RE: Letter of Objection for planning application 3/2021/0660

I am contact you with regards to the planning application number 3/2021/0660, Grid reference: 369068 450229.

We have been in contact with United Utilities following the proposed works for the Bowland section of the Haweswater Aqueduct Resilience Project, which I believe will have significant implications on our residential dwelling, the local environment and economy, and the health and welfare of those in the area.

UNITED UTILITIES WATER LIMITED
HAWESWATER AQUEDUCT RESILIENCE PROGRAMME
PLANNING APPLICATION BOUNDARY
PROPOSED BOWLAND SECTION
PAGE 1 OF 6

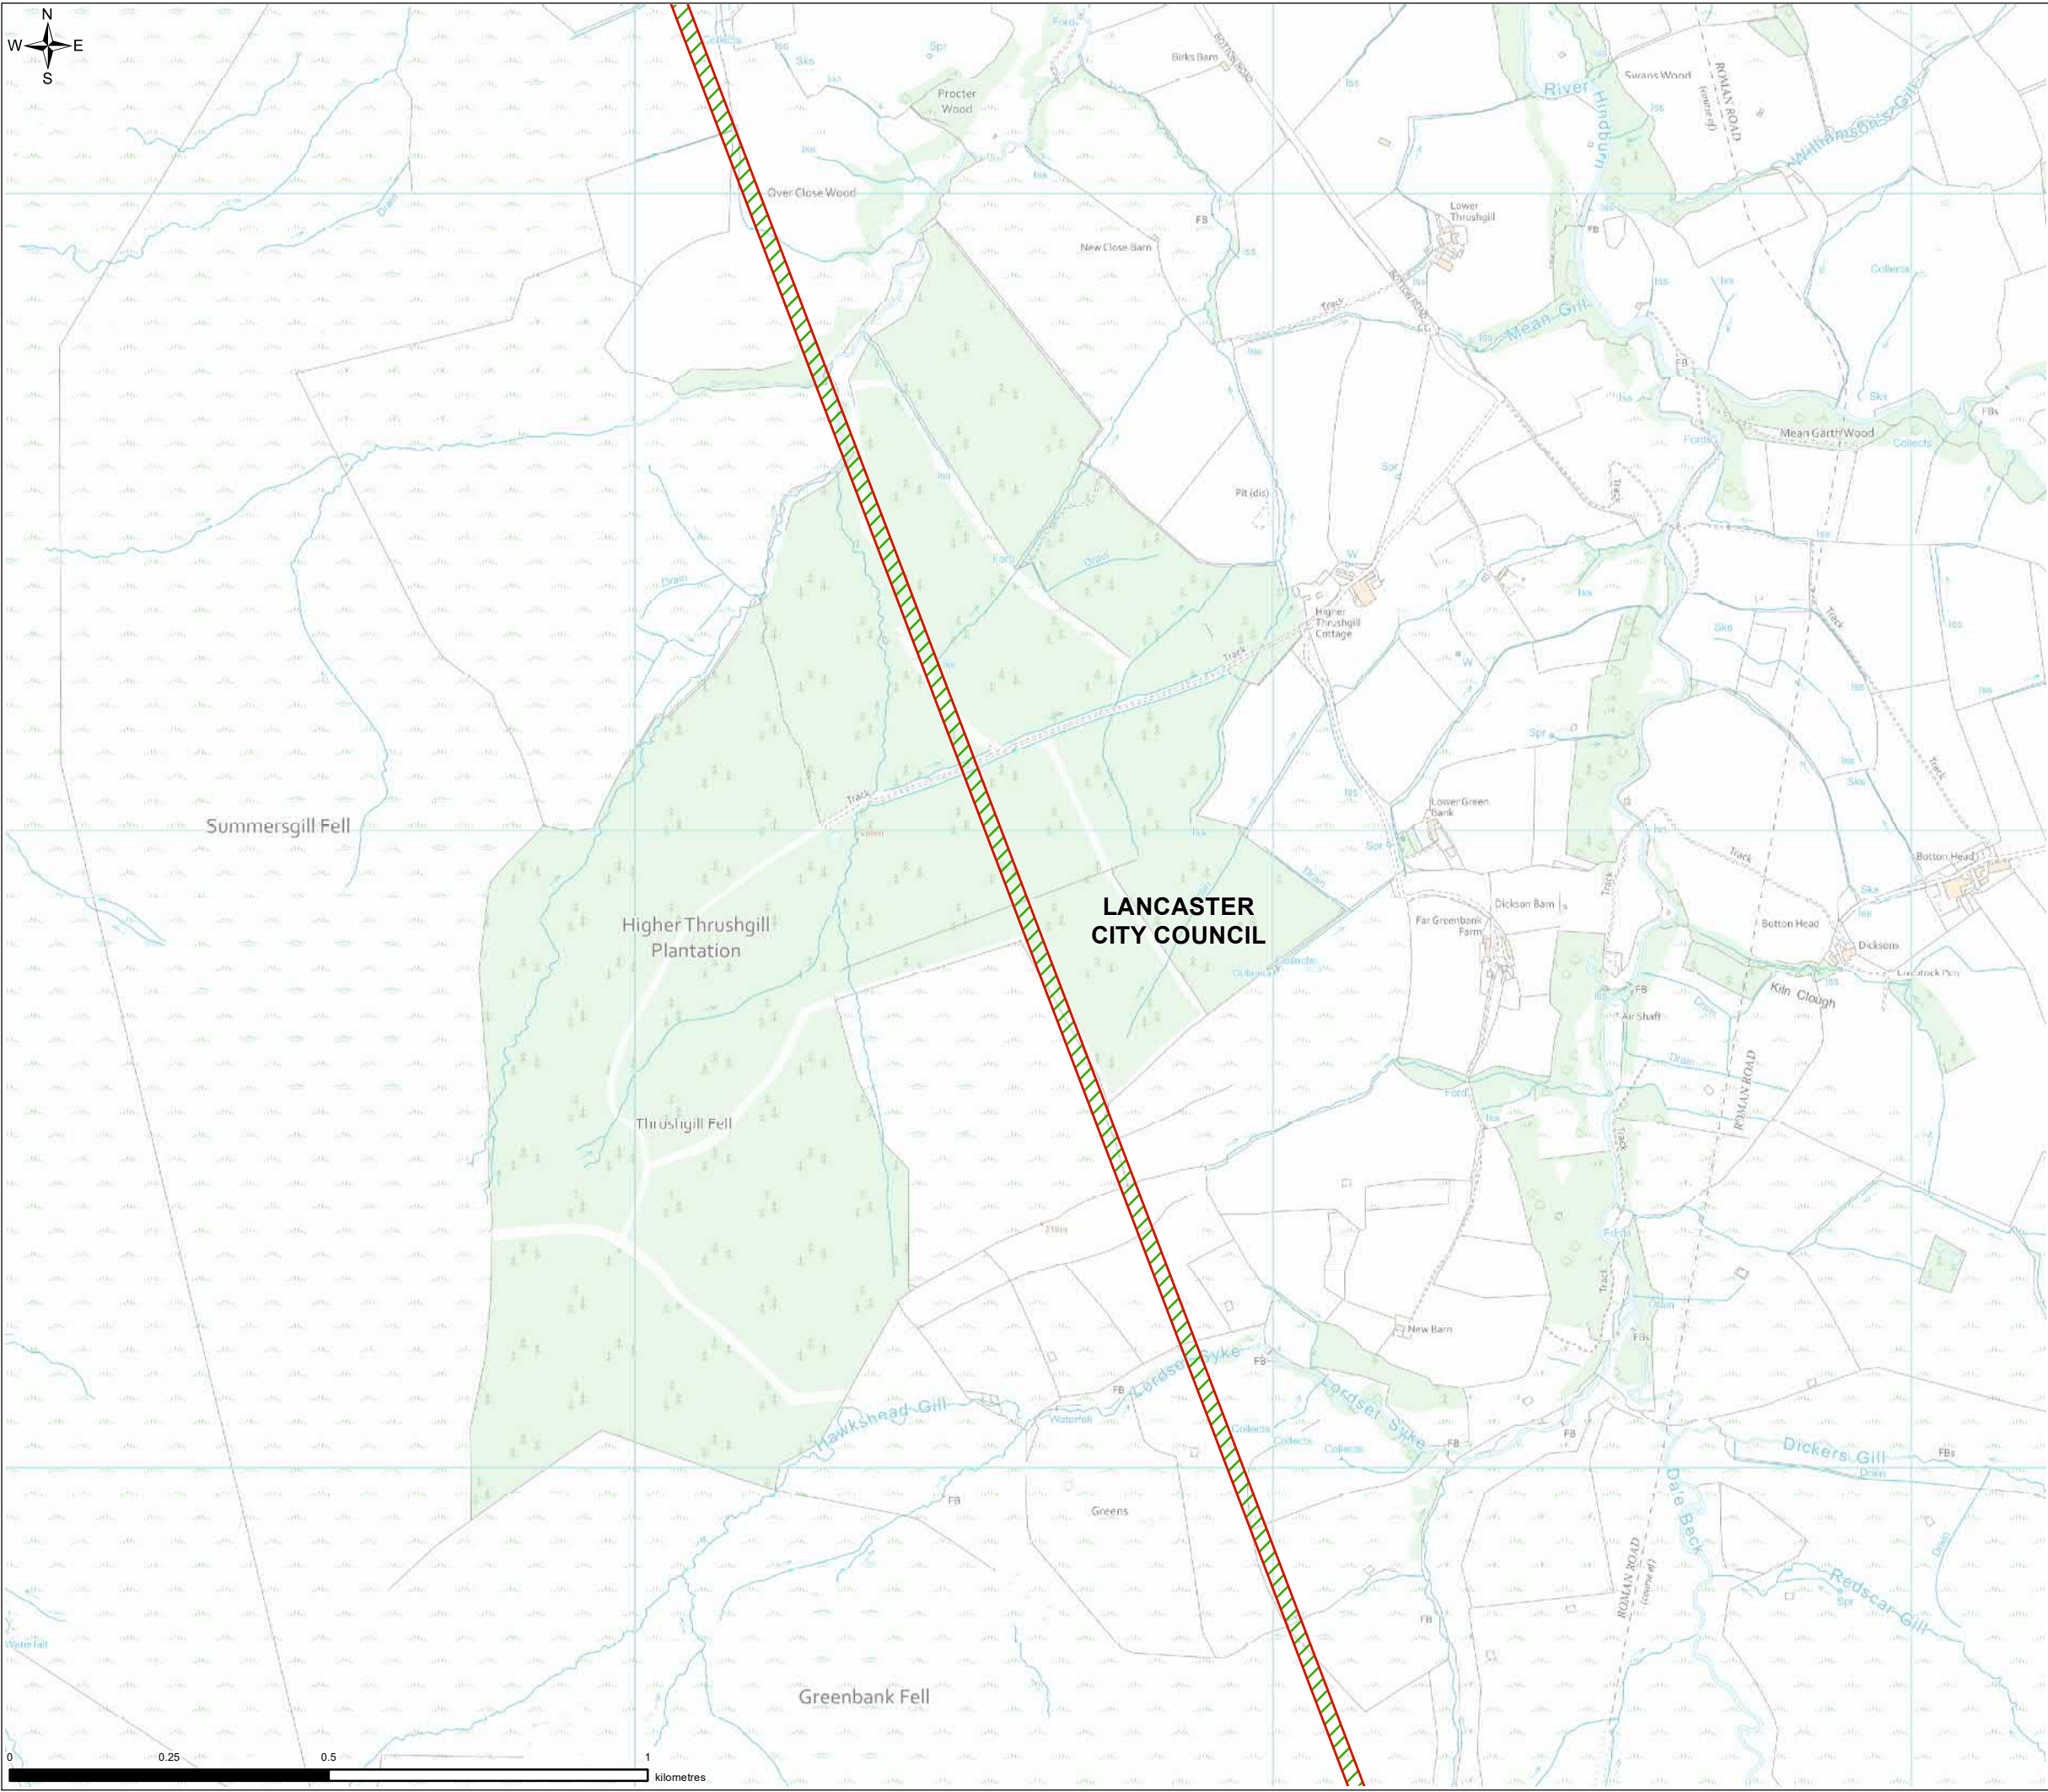
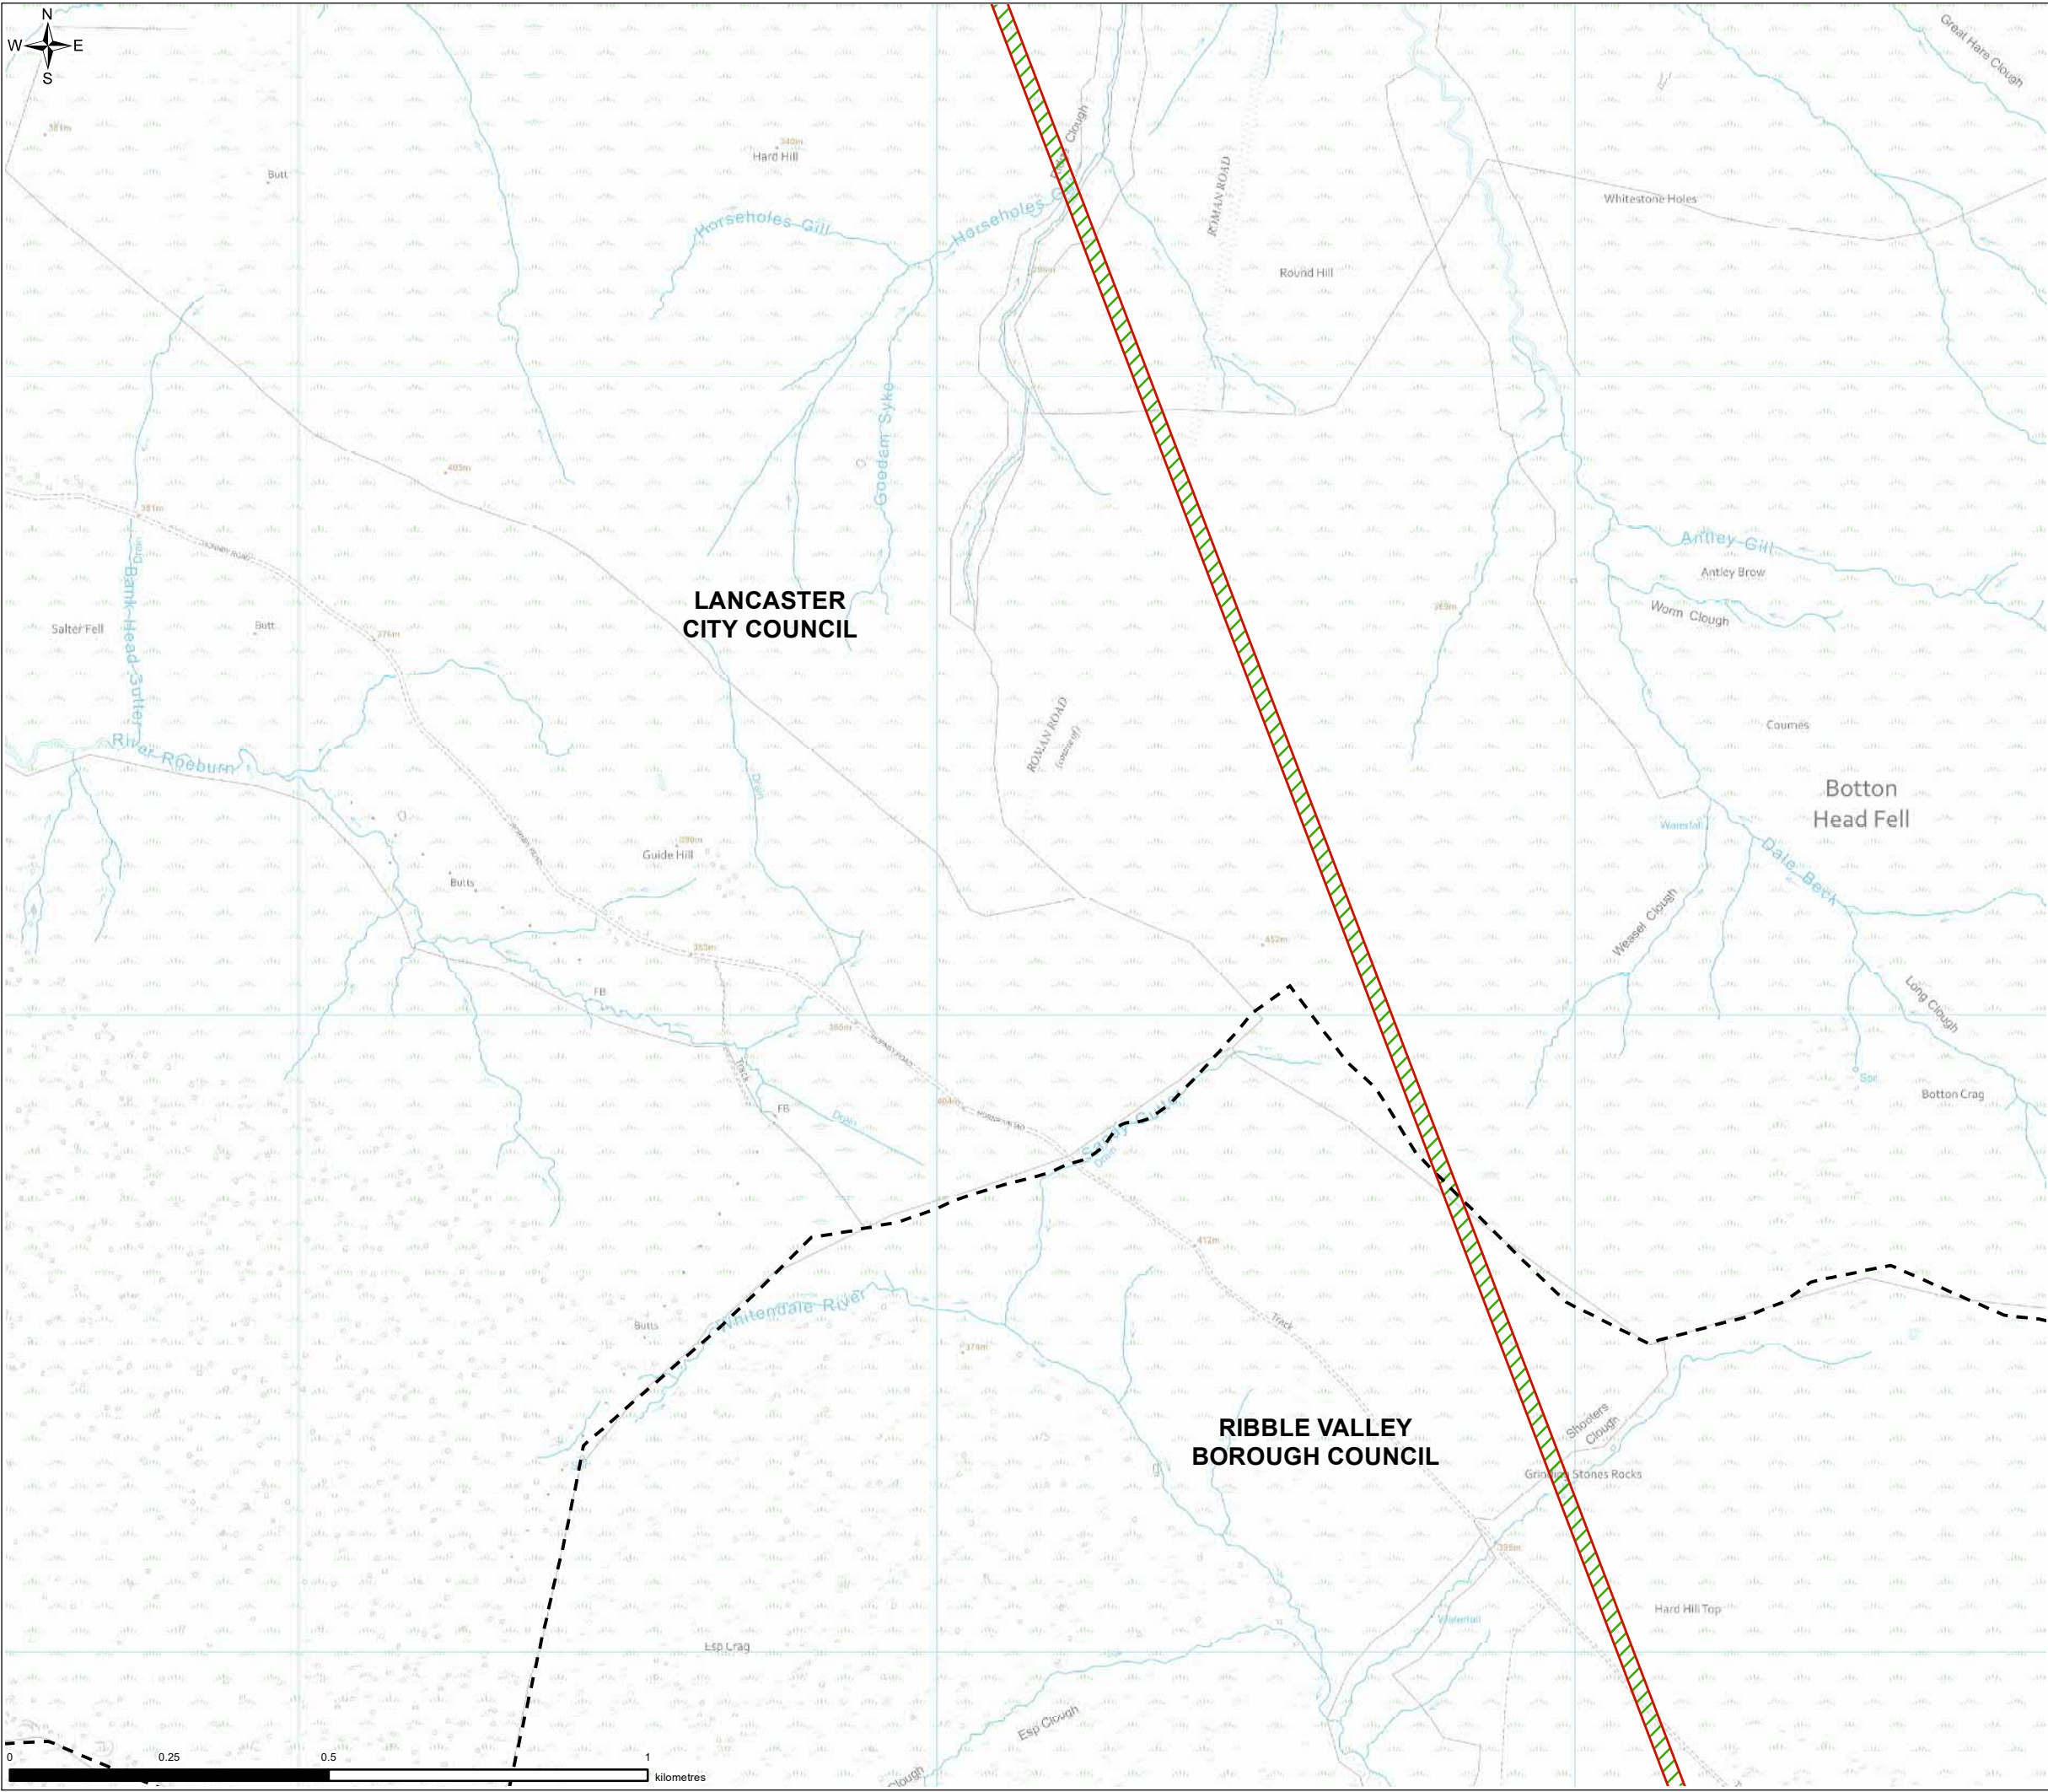
The estimated 24m buffer strip, which is the estimated boring path has moved since the original proposal United Utilities approached us with in 2019. At this stage, preliminary ground works in the form of geophysical vibriosis monitoring was done in order to estimate the ground composition prior to works. The original path and plan followed Backlane and went right by This plan has however changed in the new proposal and as such, in the planning application.

From the map below, the new bore route is closer which raises concerns with regards to building subsidence. United Utilities have stated that this is "Unlikely" but as they do not know what sort of terrain they are entering, anything is possible. If they hit rock, the vibrations alone even 100m down have the potential to cause on ground issues with building foundations. What happens if subsidence occurs when the Although this is an upsetting thought, our main concern with the works is our water supply.

I am afraid that the new pipeline plan is dangerously close to [REDACTED]. As stated previously, the original plans we were sent followed the roadside, but this map indicates that the tunnelling will be [REDACTED]. Therefore, these plans will more than likely enter our water aquifer, which the water table sits approximately from 90ft to 285ft deep, with a 110ft sleeve.
